**KIRKLEES METROPOLITAN COUNCIL
INVESTMENT & REGENERATION SERVICE**

DELEGATED DECISION TO DETERMINE PLANNING APPLICATIONS

Reference No:	2022/62/92971/W
Site Address:	59, Fixby Road, Fixby, Huddersfield, HD2 2JB
Description:	Erection of two storey side and two and single storey rear extensions with external alterations
Recommending Officer:	Laura Yeadon

HOUSEHOLDER DELEGATED REPORT

REV :

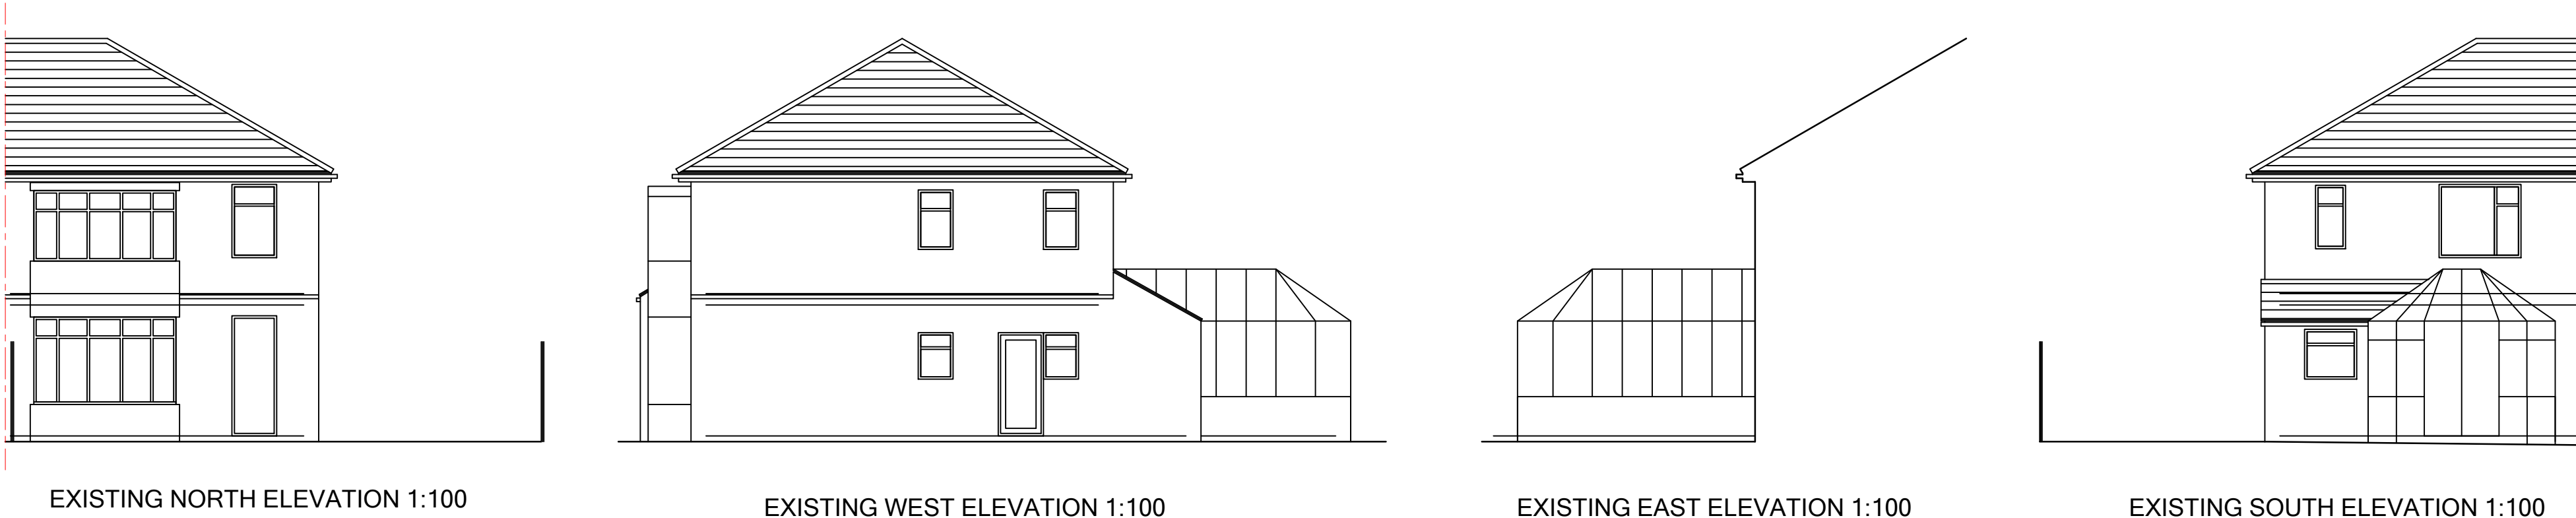
The proposed works would result in a wrap around style extension to the property. The two storey extension would be set back from the front elevation of the property by 0.5 metres and would project to the side by 3.4 metres spanning the full depth of the property, projecting off the rear elevation by 4 metres at the ground floor level.

The extension would span the width of the dwelling being set in from the shared boundary with the attached property by 0.5 metres. To the rear, the extension would be single storey at the 4 metre projection and at first floor the extension would project 2 metres. The roof line of the two storey extension would be set down from the existing with the double hipped roof to the rear set much lower than the existing roof.

Rear extensions should:	<u>Yes - COMPLY</u>	<u>No - JUSTIFY</u>
Preserve a back garden of a reasonable size, with a general principle that at least half the garden area is retained	Yes – the amenity area to the rear would be preserved to a reasonable size	
Be set behind the original building, and not projecting beyond the sides	Yes – it is proposed that the rear extensions would be incorporated into the development by tying into the proposed two storey side extension and rear roof slope, and being set

lower than the ridge of these roof slopes.	
Maintain external access to the rear garden	Yes – external access to the rear garden will be maintained to the side of the proposed extension	
Two storey rear extensions should:		
be proportionate to the size of the original house and garden	Yes – the size is considered proportionate to the original house and garden having regard to the building to which it is attached and the level of development previously undertaken to that property. In this case the proposal would read as proportionate in this context.	
not normally exceed 50% of the total area of land around the original house (including previous extensions and outbuildings)	Yes – it would comply with this	
not project out more than 3 metres from the rear wall of the original house or by 4 metres for detached properties		No - the rear extension would project by 4 metres at ground floor and 2 metres at first floor – adjacent property No. 57 is retail at ground floor with residential above – within same ownership. The building to which the dwelling is attached has been significantly extended and is of a size and scale which is such that in this case a ground floor 4m projection from the dwelling would not

have a significant impact.
not exceed a height at the eaves of 3 metres where the extension is within 1.5 metres of the property boundary		No – the rear extension would have an eaves height of over 3 metres and would be within 1.5 metres of both side boundaries – this due to the fact the extension is two storeys in height. Given the development to the attached building this is considered to be acceptable in this case.
be separated from the property boundary, such as a wall, fence or hedge, by at least 1.5 metres		No – the rear extension would not be set in by both side boundaries by 1.5 metres however is set in from the boundary with No. 61 by 1.2 meters which retains a sense of space around the building with the existing dwelling already developed up to the boundary with no.57.
not adversely affect habitable room windows where they adjoin a neighbour's boundary	Openings within side elevation of No. 61 are to a garage with openings within that dwelling that appear to be non-habitable

Side extensions should:		
Ensure reasonable levels of natural light to the habitable rooms in neighbouring properties	Yes – the proposed side elevation would be set in from shared boundary and separated from neighbouring dwelling by single storey attached garage. Whilst

there would be some impact to windows serving the garage these are non habitable and it is considered it would be unreasonable of the LPA to refuse permission on such as basis.	
Positioning windows to minimise or avoid any potential overlook into neighbouring gardens	Yes – the openings within the side elevation facing the No. 61 would be non-habitable openings. Other windows would not protrude beyond the plane of the front elevation of the host property, and are considered sufficient distance from properties to the rear to ensure no significant impact.	
Two storey side extensions should:		
not take up all or most of the space to the side of a house	Yes – the extension would be set in from the shared boundary with No. 61 by 1.2 metres	
maintain a 1 metre gap to the side boundary to ensure the building is not too close to a neighbouring property	Yes – it would comply with this	
be set back at least 500mm from the front wall of the house	Yes – the extension is set back from the front of elevation of the house by 0.5 metres

retaining host property as dominant element	
Height, scale and massing	• KDP 1 and 2 of the SPD • Policy LP24 Design (a), (c) and (d) of the KLP • Chapter 12 of the NPPF	Increase in massing by virtue of cumulative impact of extensions. Hipped roof design retained within the side extension and also, low hipped roofs within rear elevation	✓
Facing materials and detailing	• KDP 9 of the SPD • Policy LP24 Design (d) (iii) of the KLP • Chapter 12 of the NPPF	Facing materials to match the existing with fenestration details also in keeping. Two storey bay window detail retained within existing property	✓
Roof style	• KDP 1 and 2 of the SPD • Policy LP24 Design (a), (c) and (d) of the KLP • Chapter 12 of the NPPF	Hipped roof to side extension and low hipped roofs to rear elevation. In keeping with original roof	✓
Window proportions	• KDP 1 and 2 of the SPD • Policy LP24 Design (a), (c) and (d) of the KLP • Chapter 12 of the NPPF	Openings to match existing openings in terms of size and proportions. Proposed bank of patio doors within ground floor rear extension acceptable for a residential extension	✓

Relevant key design principle (KDP) of the SPD, Policy in the Kirklees Local Plan and the NPPF	Further comments	✓ / X / N/A
Impact on privacy of neighbours (to sides, rear and front)	• KDP 3 & 4 of the SPD • Policy LP24 Design (d) (iv) • Chapter 12 of the NPPF	Openings facing No. 61 are non-habitable and therefore minimal concerns – no openings facing attached neighbouring property. There are no boundary treatments separating the host dwelling from the amenity space for the attached property or the proposed amenity space for the converted and extended garage/outbuilding given under one ownership. There is no boundary screening between the habitable room openings within the extensions and outbuilding/garage and the proposed garden area for the dwelling however as the proposed	✓

YES / NO	SUMMARY
Negotiations/Amendments during course of application	Yes	Amended plans were requested which demonstrated the extent of development proposed due to other applications submitted within the site – received 9th October 2023 Further amendments were requested to align the application with the current requirements of the SPD whereby the roof line of the two storey side extension was lowered – received 8th February 2023 under reference number 1978-22-003 – Rev: D. It was noted that the red line boundary of the site included land forming part of the adopted highway

which is outside the ownership of the applicant. As a consequence, the red line boundary was reduced to only include land owned by the applicant.
Parish/Town Council comments sought	N/A	
Planning History		<u>Application site</u> 2019/92709 – Erection of extension and alterations to outbuilding and garage to form one dwelling and widening of vehicular access to Fixby Road – Approved <u>Attached property No. 57</u> 1989/07343 – Erection of 2 storey extension to form enlarged sales area, 2 bedrooms and bathroom – Approved 2005/94734 – Alterations to existing garage – Refused 2006/94561 – Erection of storage unit – Approved 2011/92679 – Installation of ATM and associated works – Approved 2019/92708 – Certificate of lawfulness for proposed change of use of grand floor from residential to retail – Refused 2022/93096 – Erection of extension and external staircase – <i>under consideration – not yet determined – committee decision request submitted</i> 2022/93373 – Erection of extensions and alterations to outbuilding and garage to form one dwelling – <i>under consideration – not yet determined</i>

Pursuant to article 35 (2) of the Town and Country Planning (Development Management Procedure) Order 2015 and guidance in the National Planning Policy Framework, the Local Authority have, where possible, made a pre-application advice service available, complied with the Kirklees Development Management Charter 2015 and otherwise actively engaged with the applicant in dealing with the application. Amended plans were requested to demonstrate all the proposed works within the blue line boundary and also to set the roof down to comply with the SPD.
